Stage 1 RSA - Road Safety Audit Response Report [Rev P2]

1.1 This report results from receipt of a Stage 1 RSA Report, undertaken dated March 2017.

GENERAL ARRANGMENT DRAWING (1 OF 2)

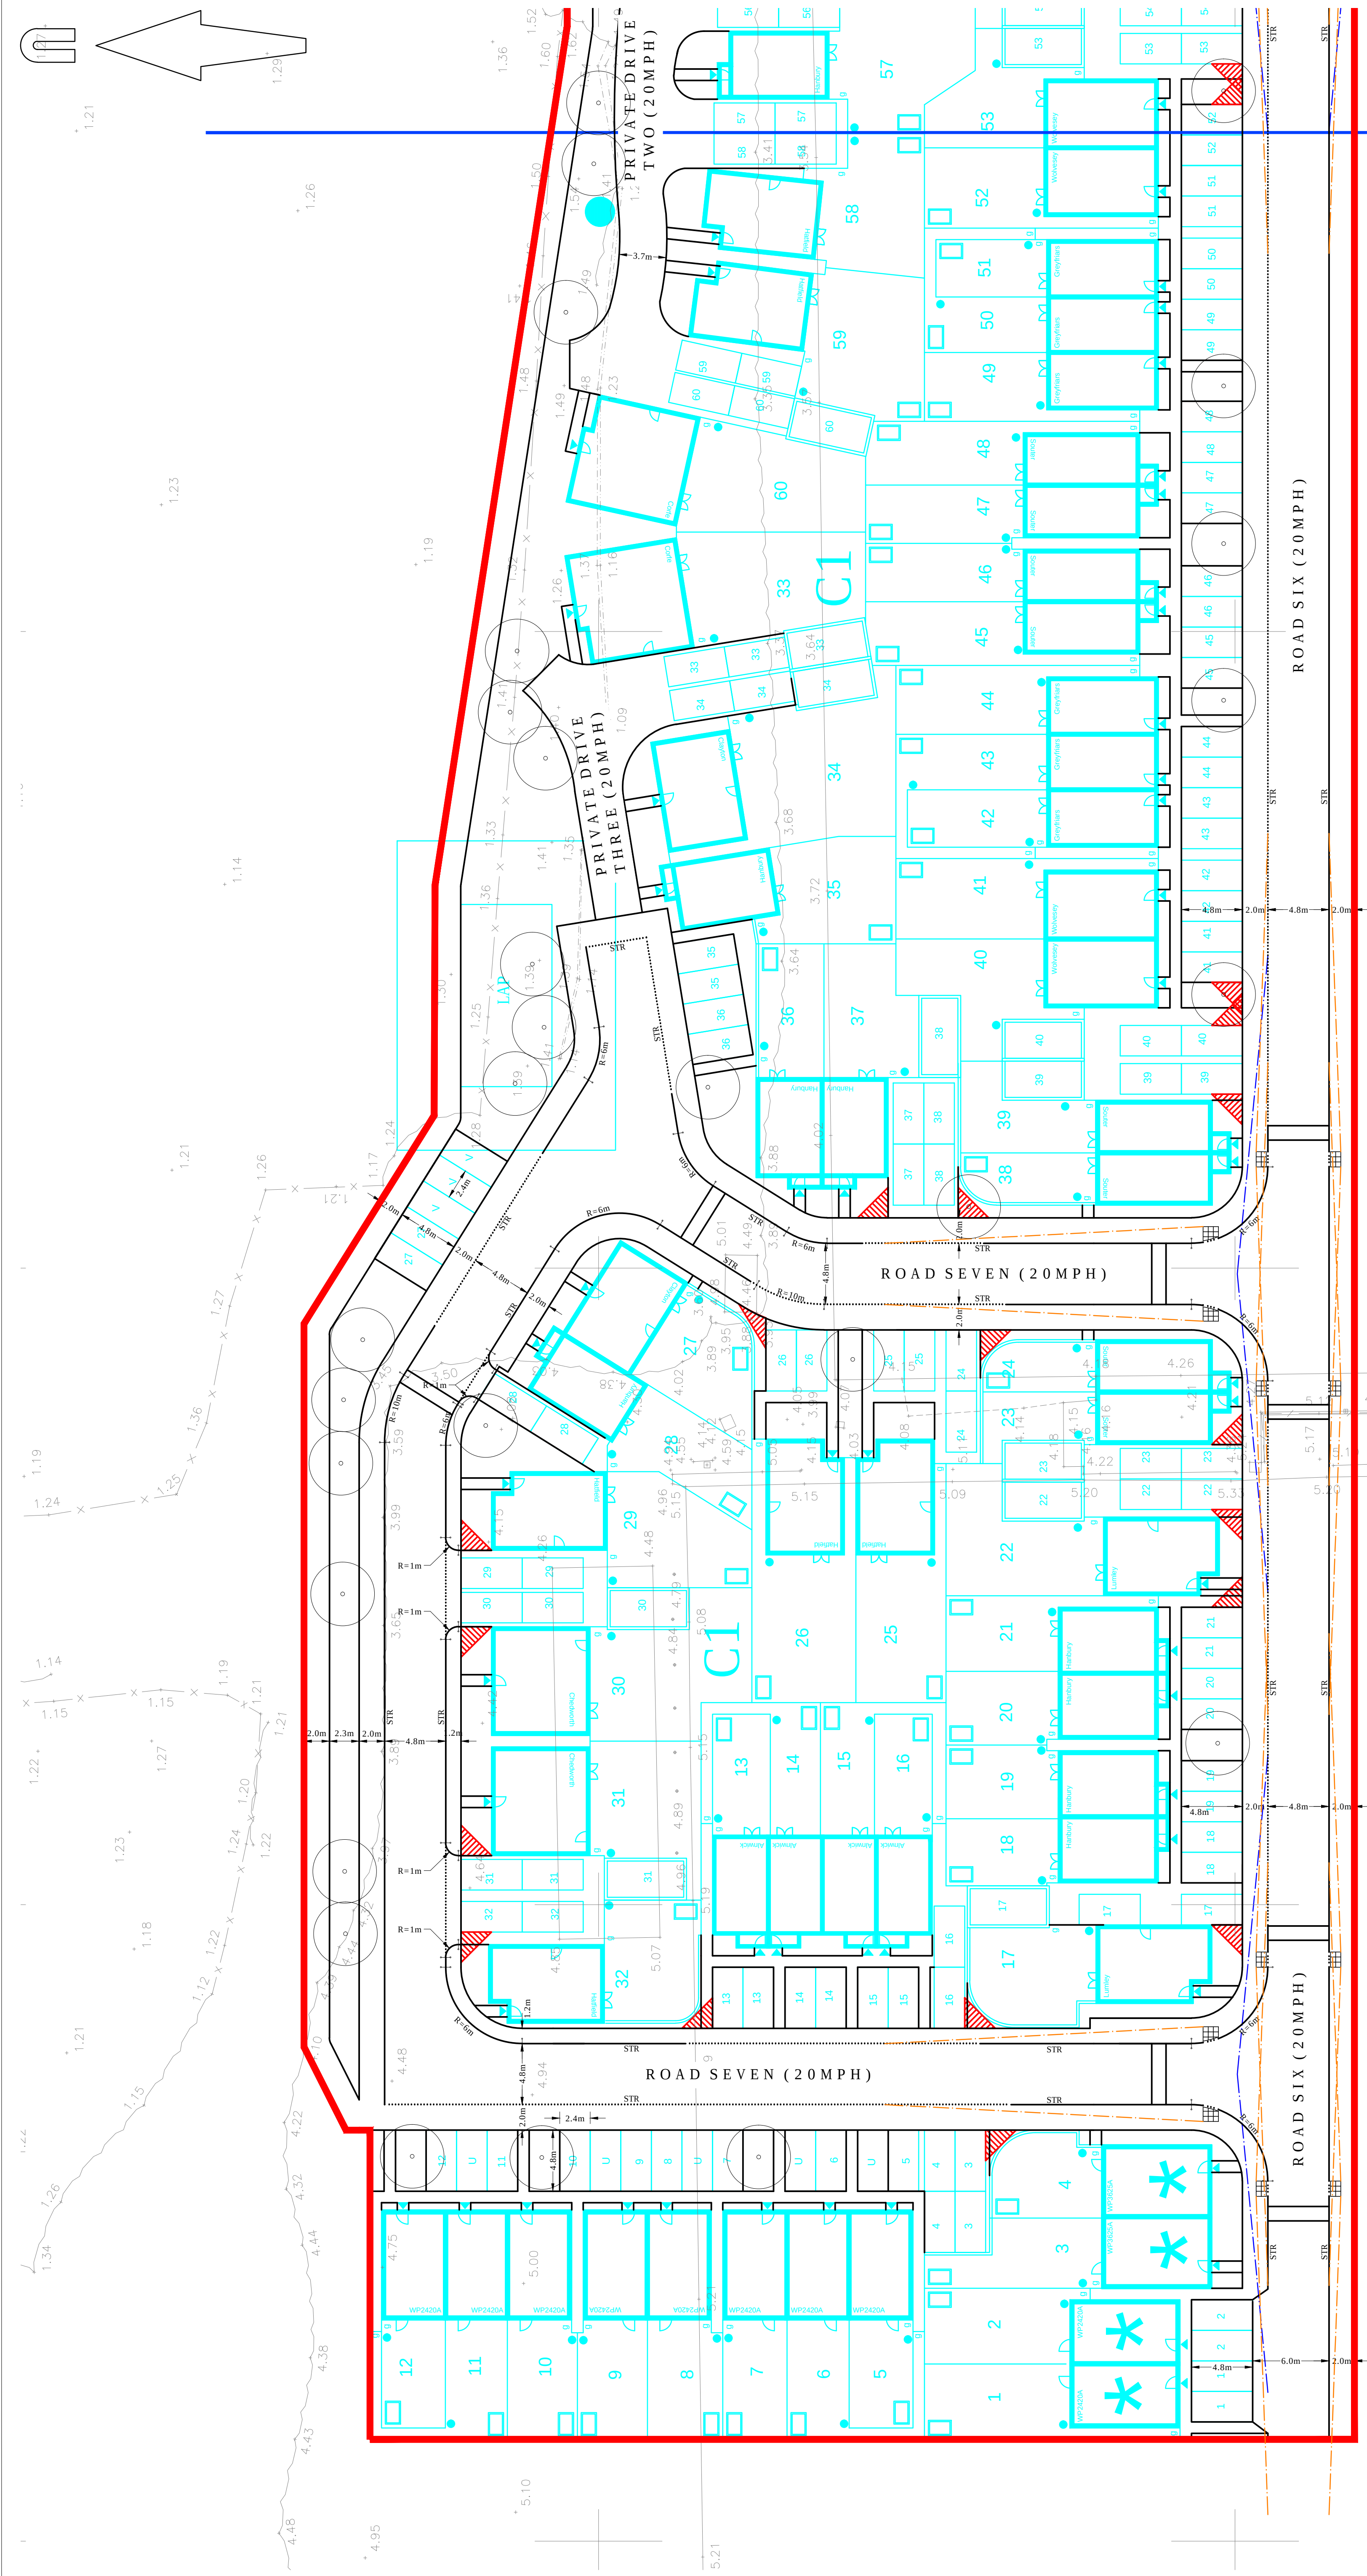
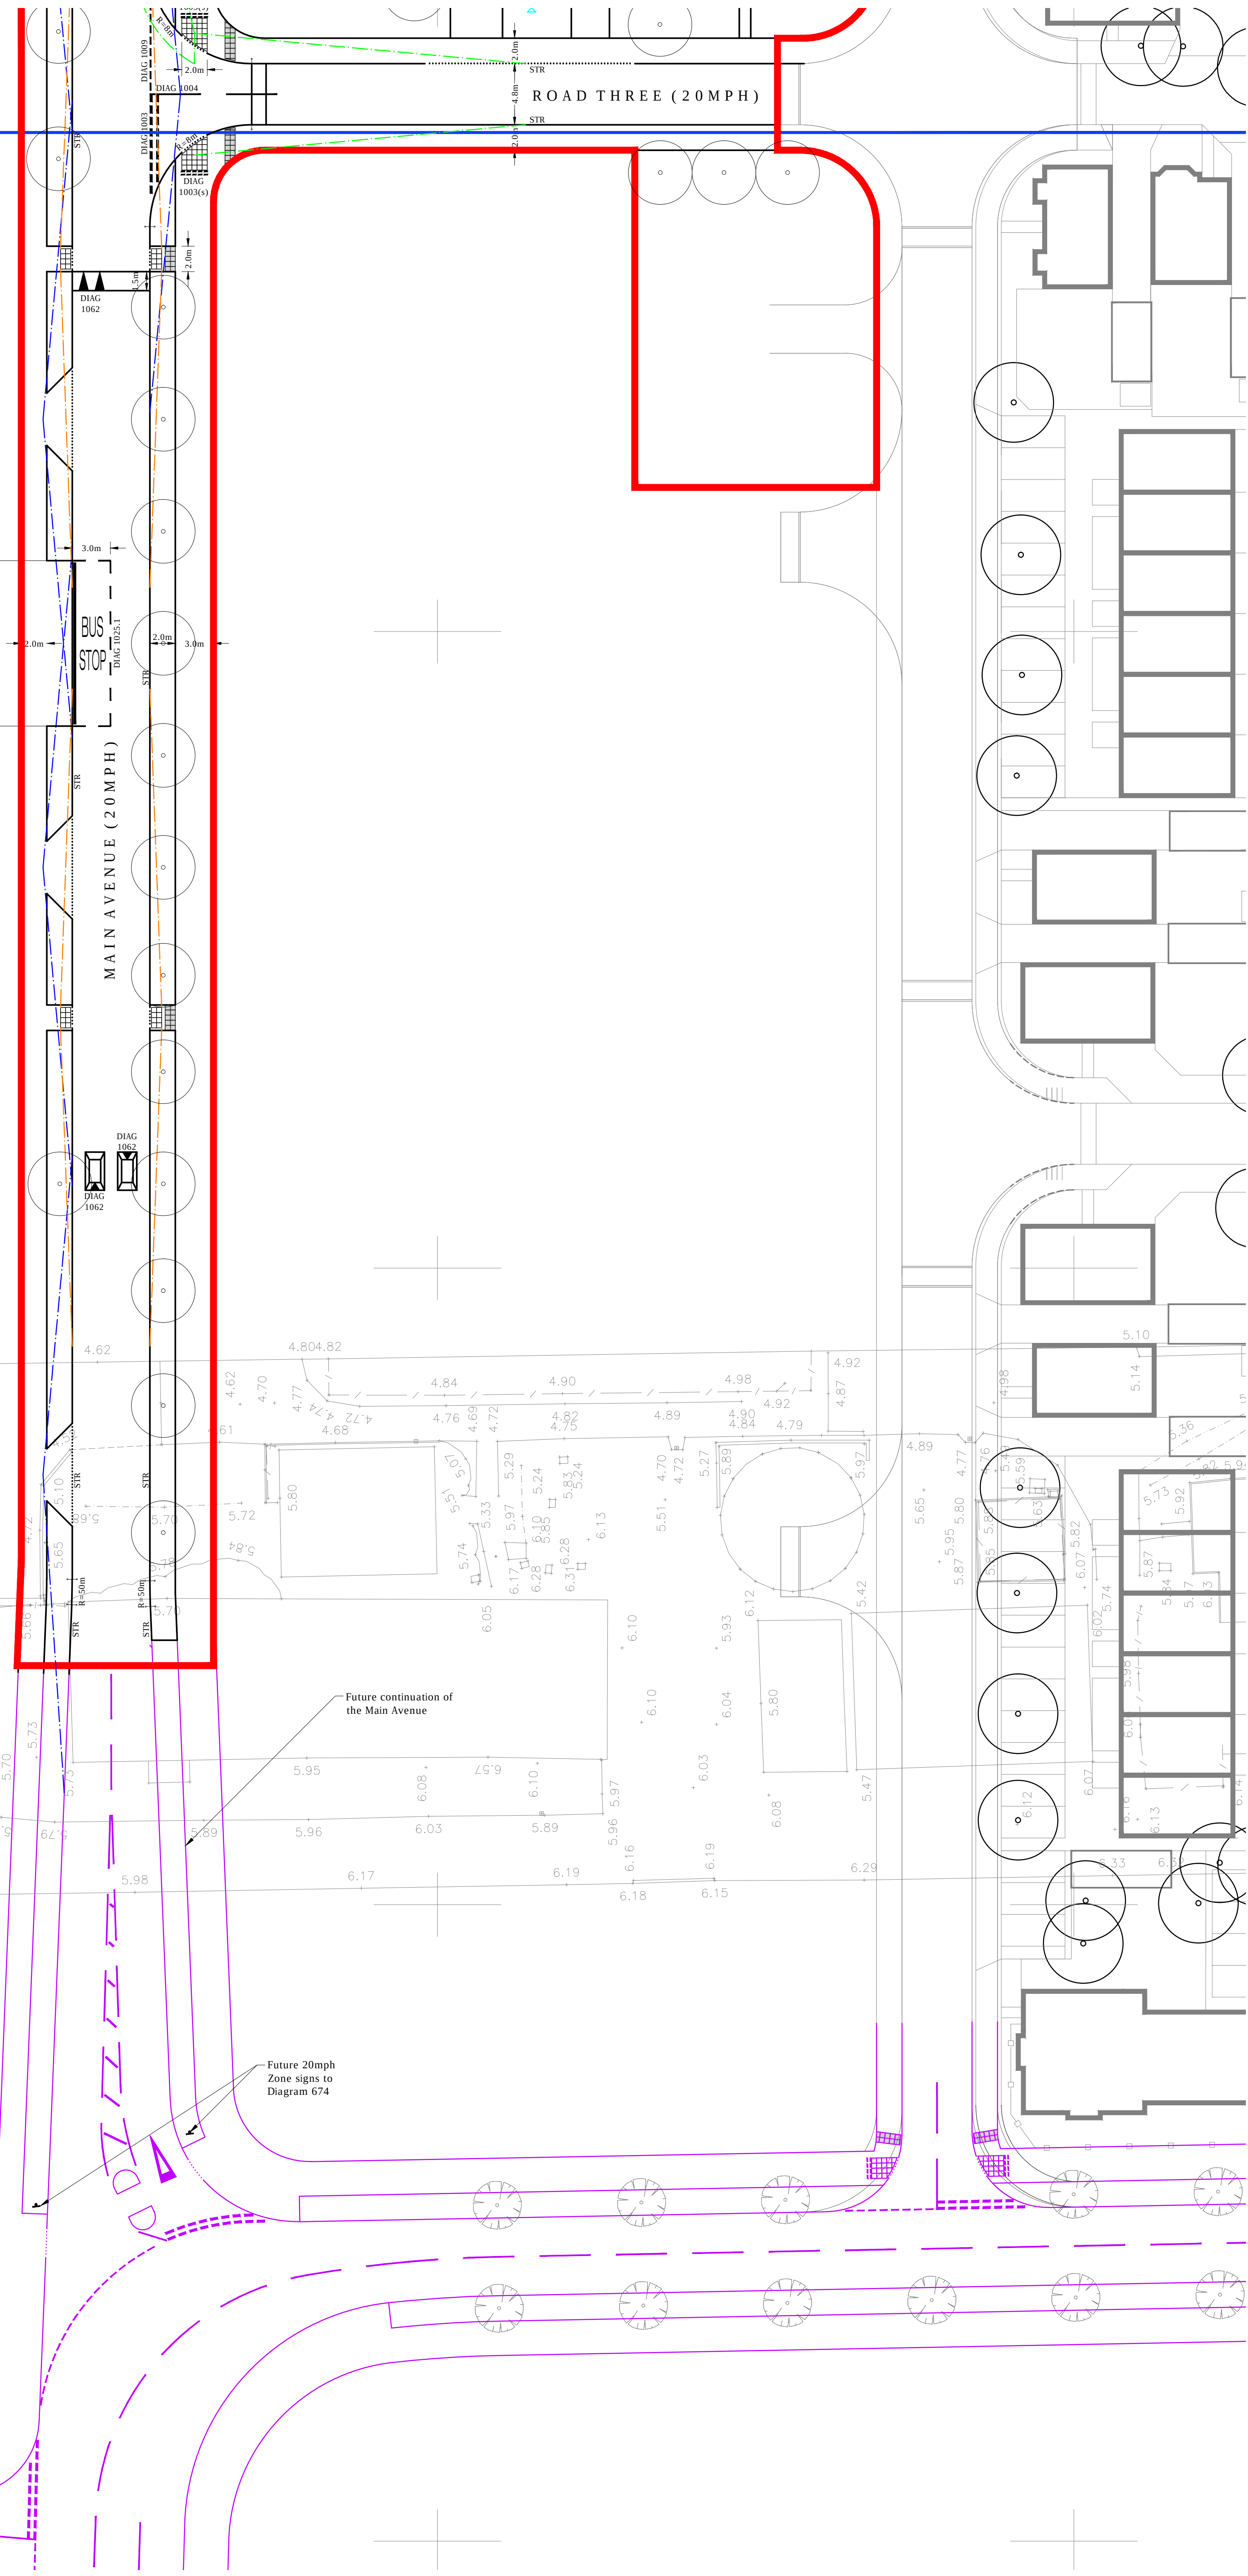
Item	Problem	Recommendation	Designer's Response
2.1	Location: General Summary: Visibility splays Junction visibility splays have not been detailed consistently on the drawings submitted at this stage. A number of splays are shown to the channel line and others are shown to the centre line / offside lane. Forward visibility splays have not been detailed. Pedestrian inter-visibility splays have not been detailed on all of the general arrangement drawings provided. It will be important that adequate splays are provided, this should include junction, pedestrian inter-visibility and forward visibility splays.	Provide visibility splays in accordance with relevant design standards and ensure that the splays will be kept free from obstruction. Any vegetation within the splays should be maintained to ensure that it does not extend beyond a vertical height of 0.6m. If planters are to be provided then these, together with any foliage which they contain, should also not extend beyond a vertical height of 0.6m.	The Design speed of the development is intended to be 30mph for the short adopted section of the Main Avenue and 20mph elsewhere. As a result, in accordance with LTN 1/07 Traffic Calming measures are proposed with a maximum of 70m spacing. In consideration of the above, visibility splays provided are indicated as 2.4m x 25m (20mph) and 2.4m x 43m (30mph), as set out in MfS. As recommend any vegetation within vis splays shall be 0.6m or less. A note added to General Arrangement drawings "Any vegetation within the splays should be maintained to ensure that it does not extend beyond a vertical height of 0.6m."

Item	Problem	Recommendation	Designer's Response
2.2	Location: Main Avenue (Please refer to reference point 2.2 in Appendix B) Summary: Possible injury to bus passengers as a result of vertical deflection. A raised table at this location is likely to be detrimental to bus passenger safety as vertical deflections will occur as passengers rise from seats and / or use the stairs within the bus, on approach to the bus stop.	Either: 1. Relocate bus stop away from raised table 2. Relocate raised table away from bus stop	Accepted. The traffic calming feature on approach to the bus stop has been removed.

2.3	Location: Uncontrolled crossing point east of bus stop (Please refer to reference point 2.3 in Appendix B) Summary: Crossing pedestrians masked by stationary bus If a bus is stationary within the bus stop then the crossing point sited to the east of it will be masked from drivers approaching from the west. This could result in pedestrians stepping out front of a moving vehicle, potentially resulting in injury. The Audit Team have considered the same issue with the crossing located to the west of the bus stop. However, it was agreed that this did not provide a safety risk as westbound drivers will already be slowing significantly for the raised table prior to the crossing point.	Relocate eastern crossing point away from the bus stop, ensure appropriate forward visibility splays to the pedestrian landing points can be achieved.	Accepted. Bus stop relocated. Visibility splays to pedestrian crossing locations indicated as recommended.

Item	Problem	Recommendation	Designer's Response
2.4	Location: General Summary: Junction markings within the internal residential development The priorities indicated are unnatural and would probably quickly be disregarded by residents and frequent users. The change in surface and raised junction tables would add an element of uncertainty that might reduce speeds and increase concentration to those unfamiliar with the development.	Omit junction markings on raised tables / block paving within the internal road network of the development site.	Accepted. It is considered that the giveaway markings on the Main Avenue junctions should be retained as these provide priority to the Main Avenue traffic route. However, giveaway markings on other junctions within the internal road network have been omitted as recommended.

2.5	Location: General Summary: Ramp warning triangles There are a number of ramps / raised tables provided within the internal residential layout. It will be important that approaching drivers / riders are able to identify these ramps on approach so that they can adjust the speed / riding position as appropriate to reduce the risk of losing control.	Provide white warning triangles (Diag 1062) on all speed reducing ramps.	Accepted. Triangular road markings to Diag 1062 shall be provided at all speed reducing ramps as recommended.
